REQUEST

Current Zoning: O-2 (office)
Proposed Zoning: MUDD(CD) (mixed use development, conditional)

Approximately 1.55 acres located along the southeast side of Colonial Avenue, along the west side of Vail Avenue, and the northeast side of Randolph Road.

Flagship Healthcare Properties, LLC

CONDITIONAL REZONING PLAN

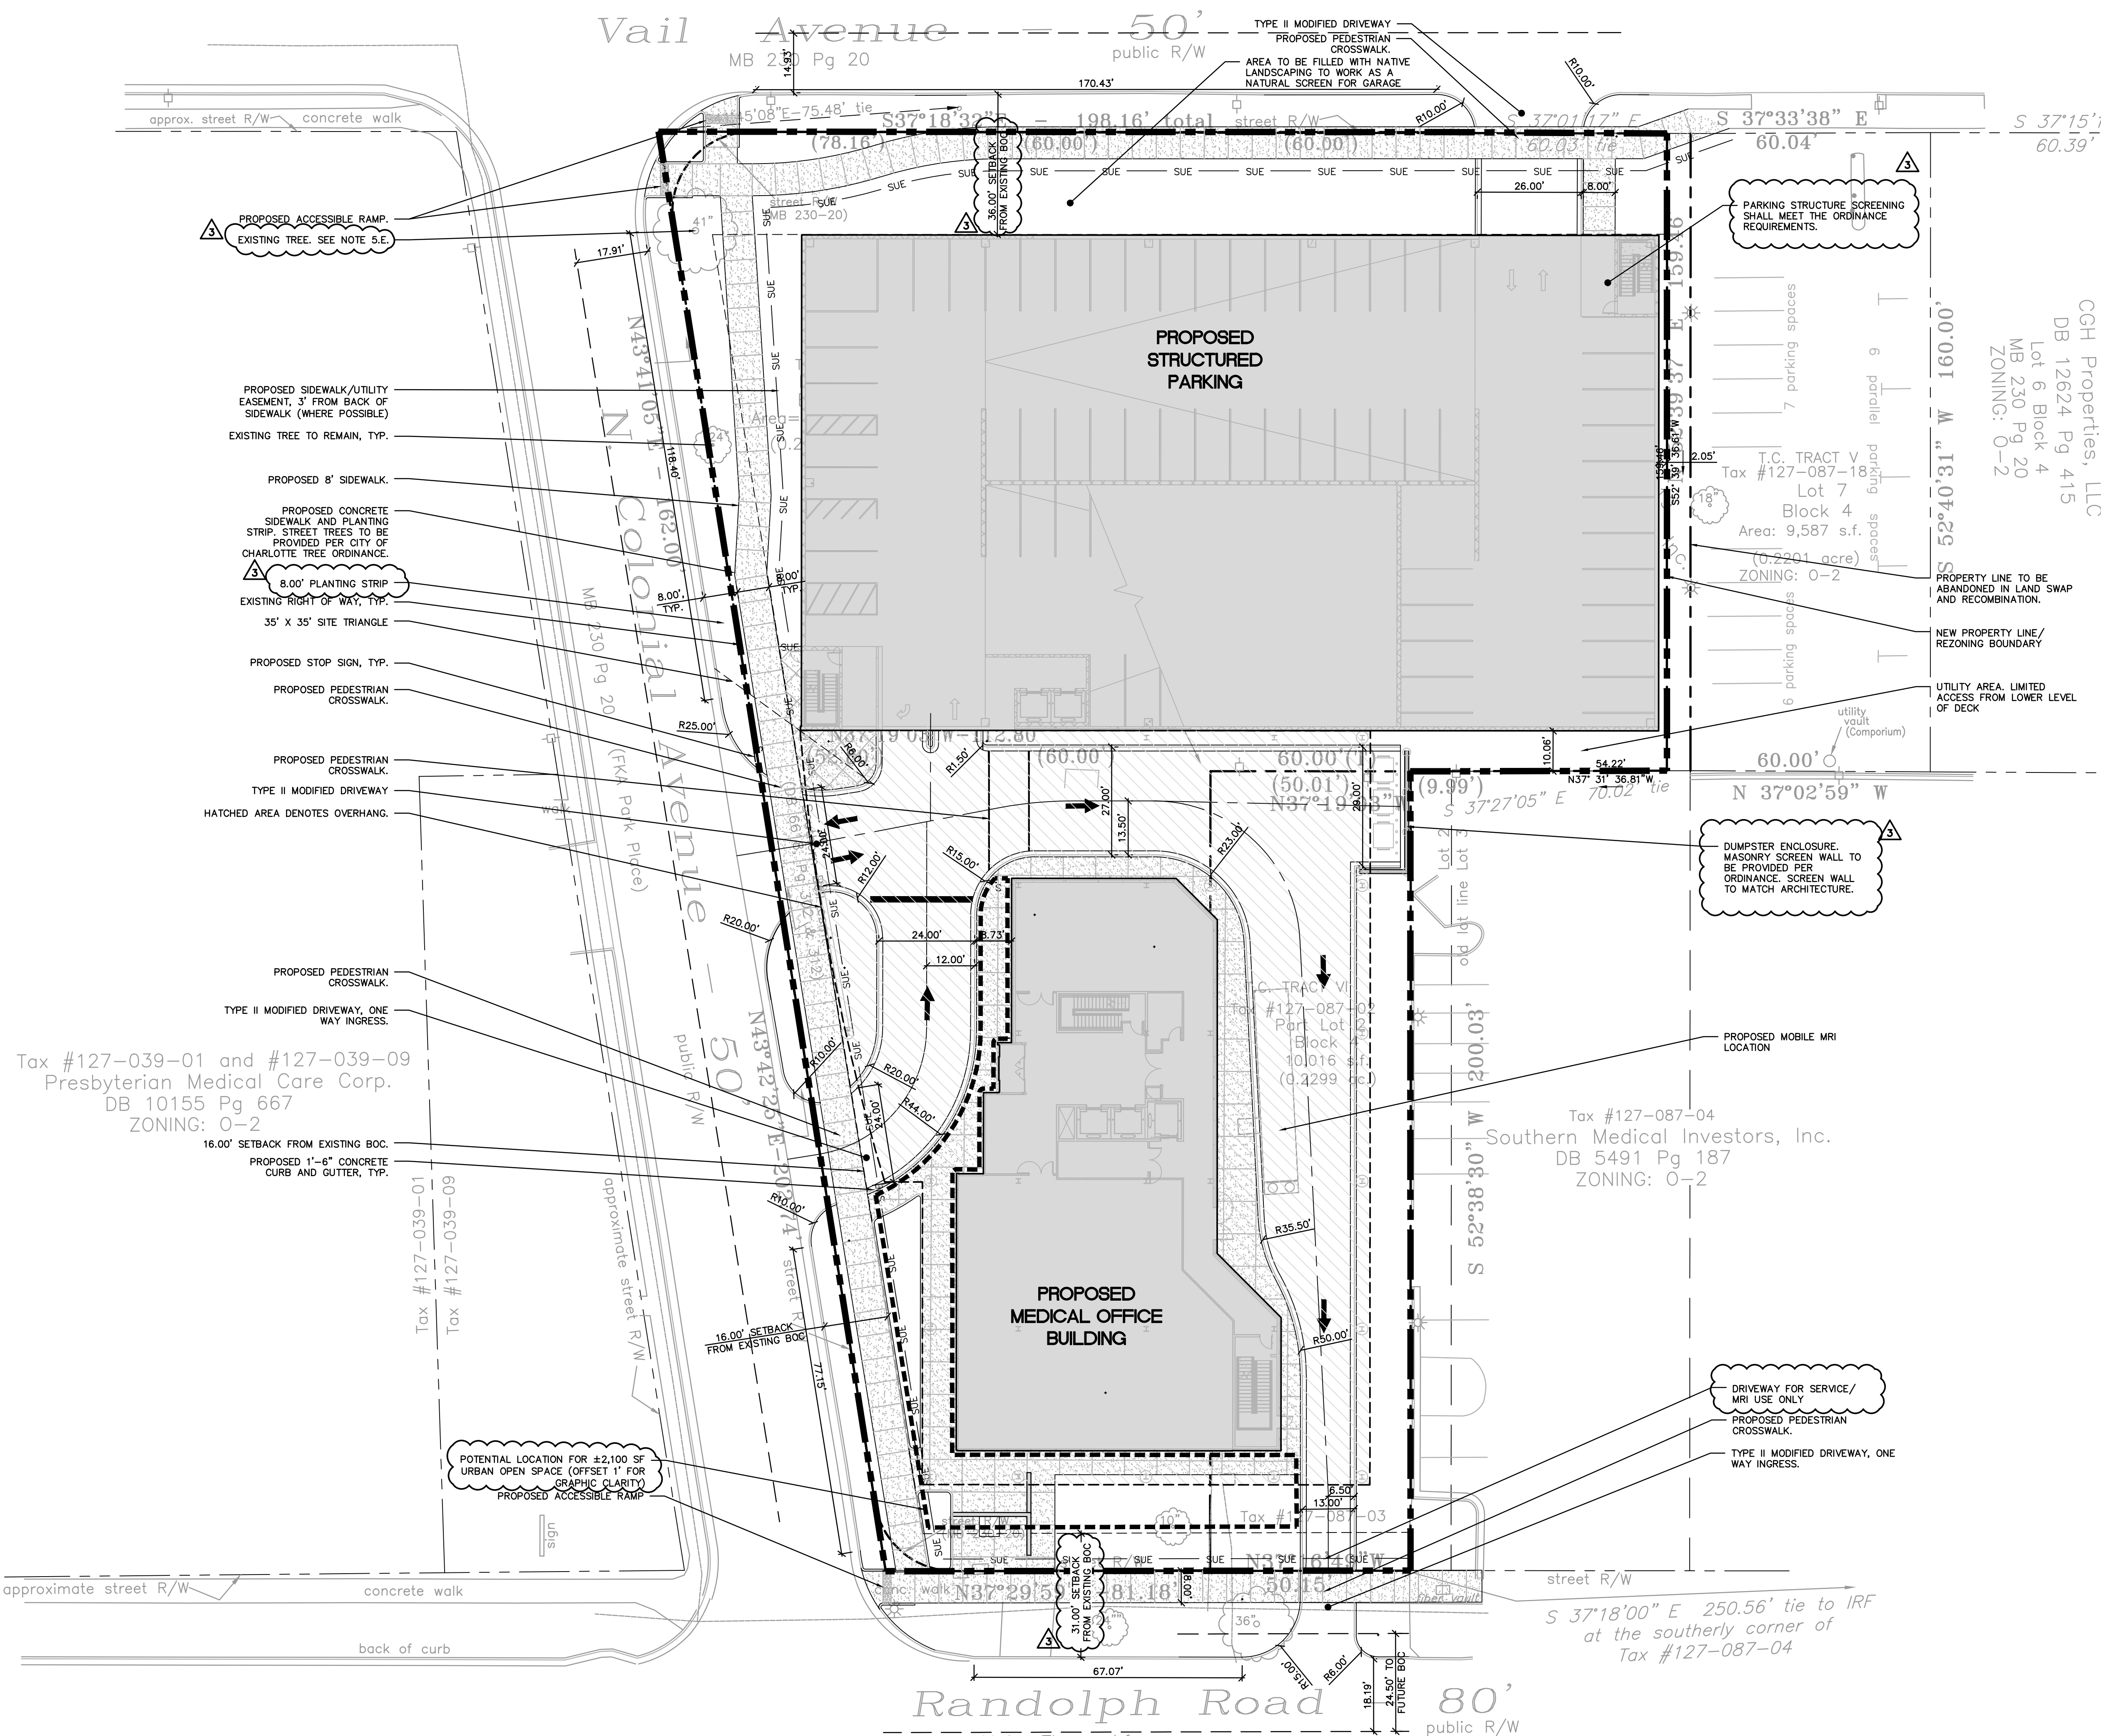
1. Under Site Development Data remove reference to number of stories.
 2. Label 8-foot sidewalk and 8-foot planting strip along Randolph Road and Vail Avenue.
 3. The setbacks labeled on the site plan are different from the 14' noted under Rezoning Summary. The setbacks will need to match what is shown on the site plan.
 4. On the Elevations sheet label east, west elevation (or identified street view). Signage is not part of this review.
-
